July 18, 2025

Reference: Geotechnical Review of Grading Plan for Proposed Building Addition, 8560 Campeau Drive, Ottawa, ON

PROJECT No.

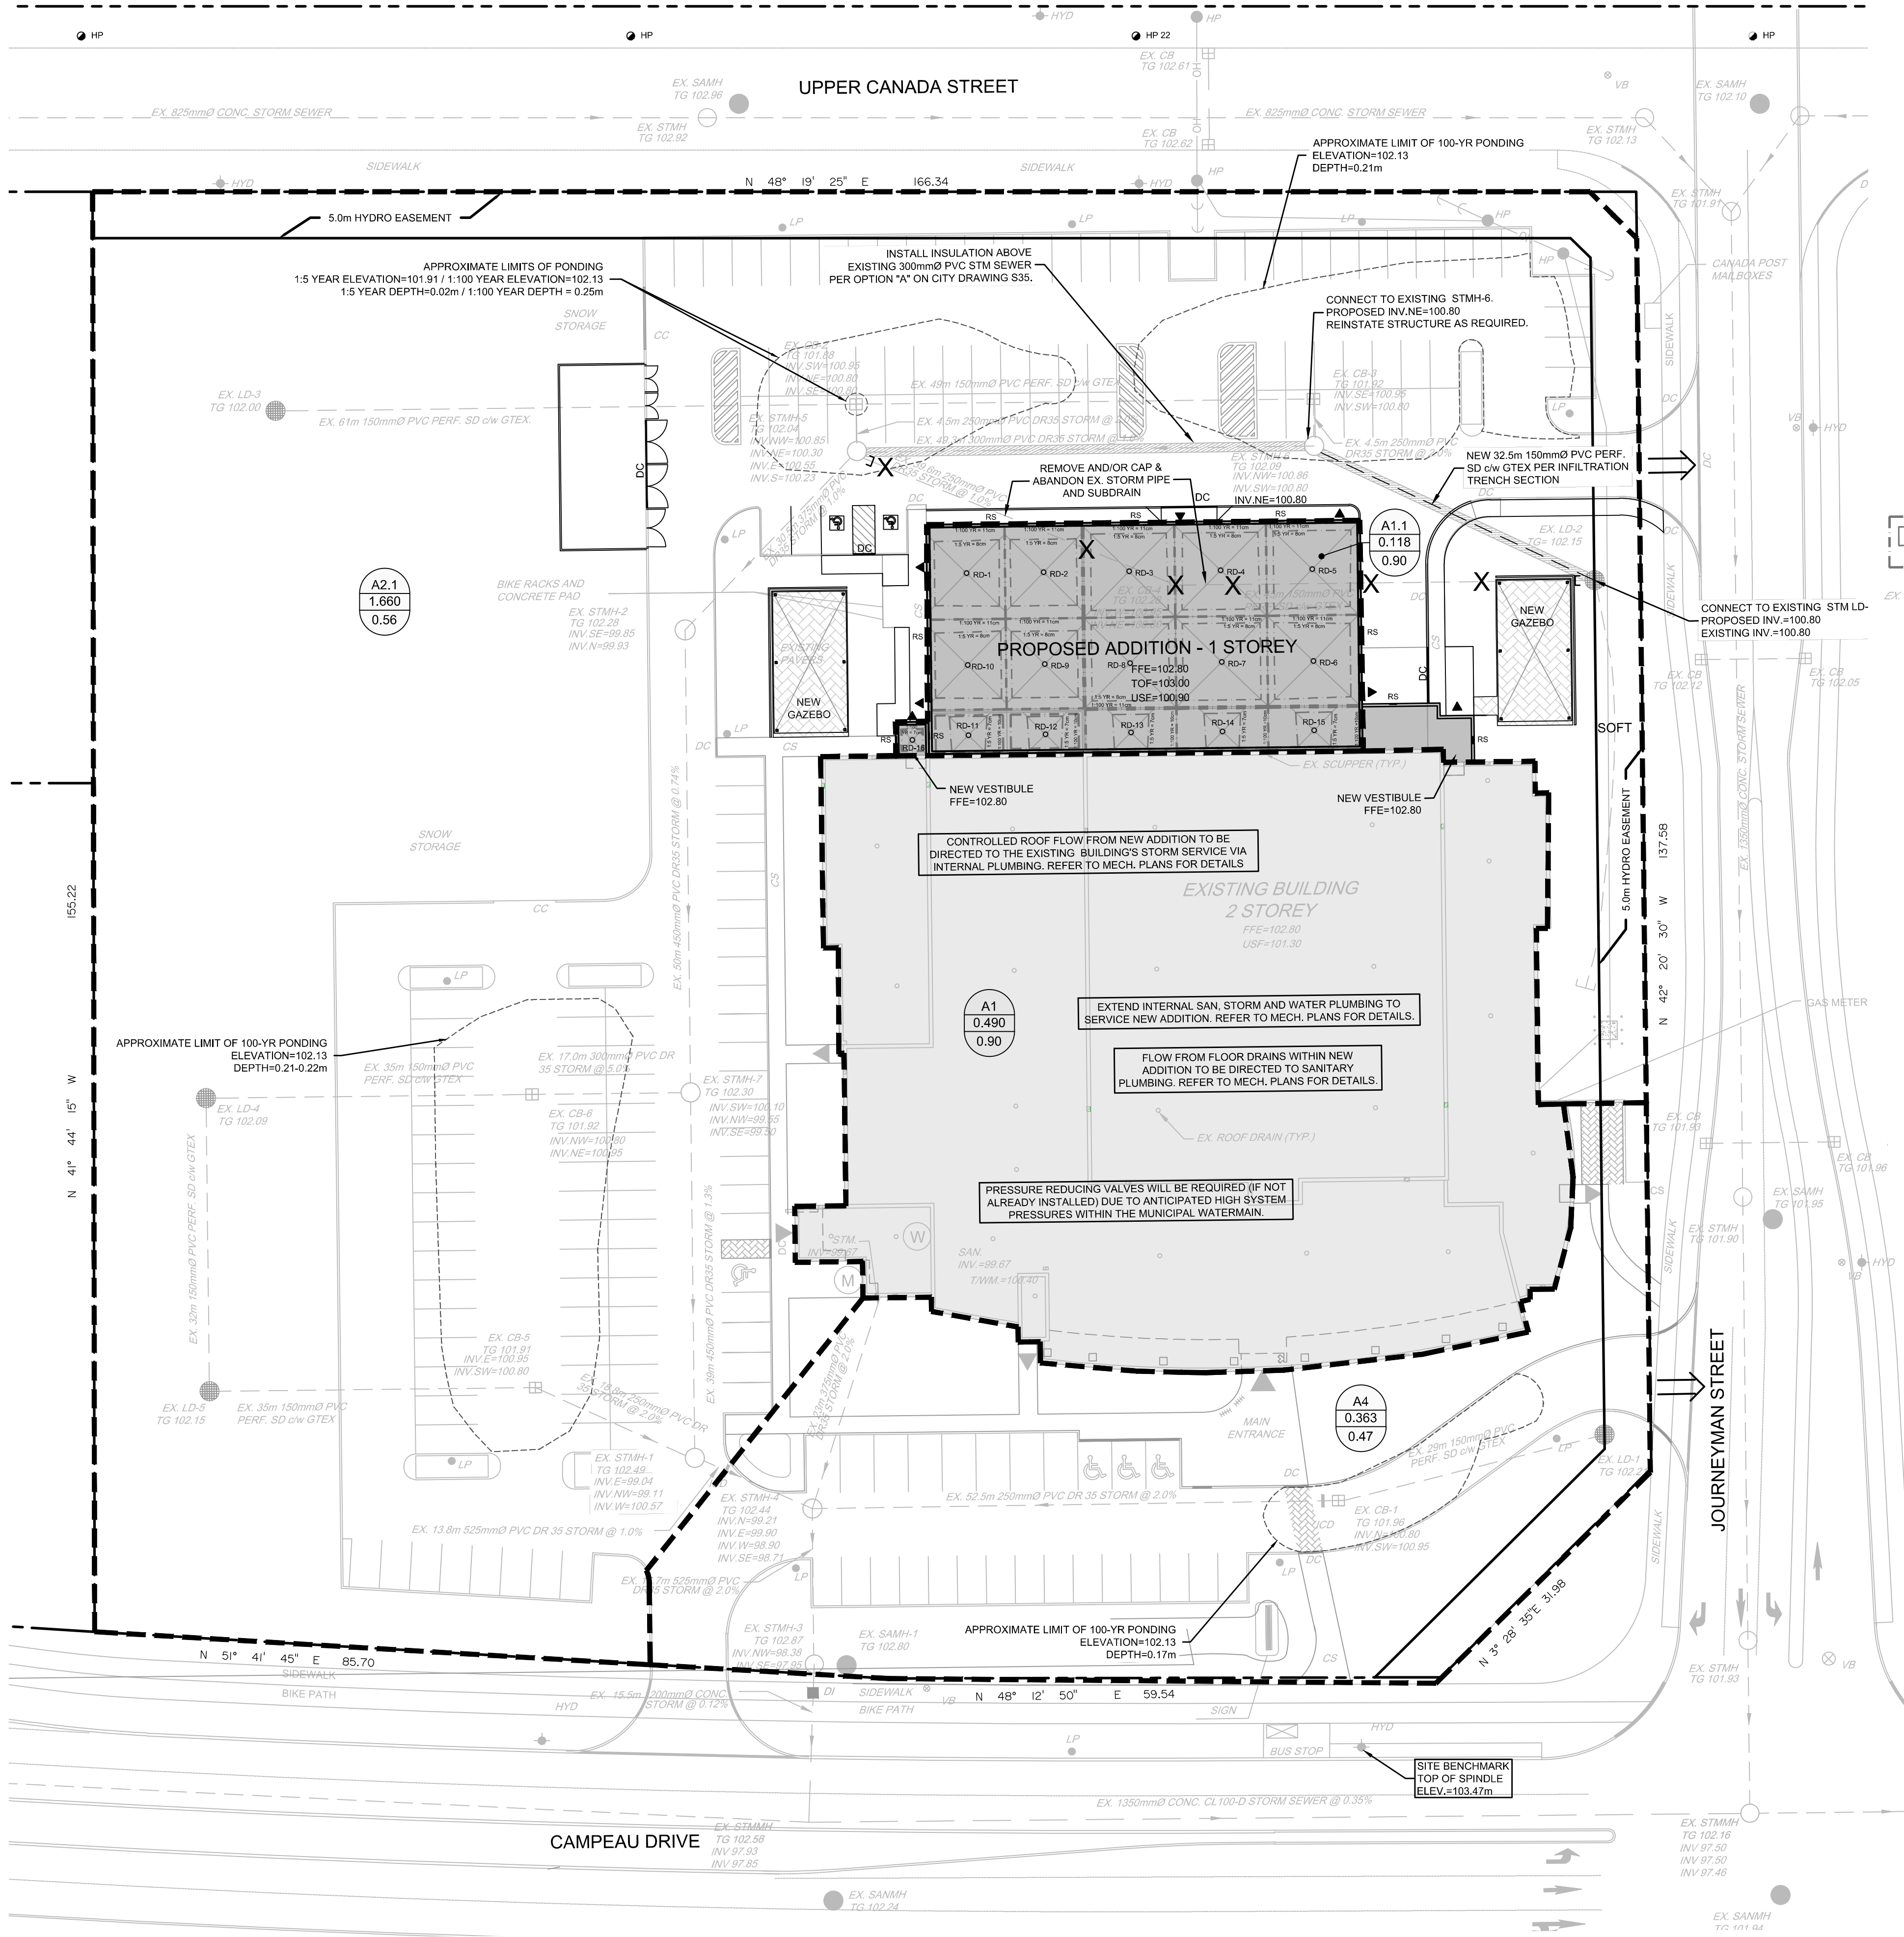
This letter documents the geotechnical review of the site grading plan for the proposed building addition. The reviewed drawing (No. 123082-GR, "Grading and Erosion & Sediment Control Plan," dated July 14, 2025) shows a finished floor slab elevation of 102.8 m, matching the existing building and includes minor grading near the addition. Stantec has no concerns with the proposed site grades with respect to the settlement of the underlying clay soils.
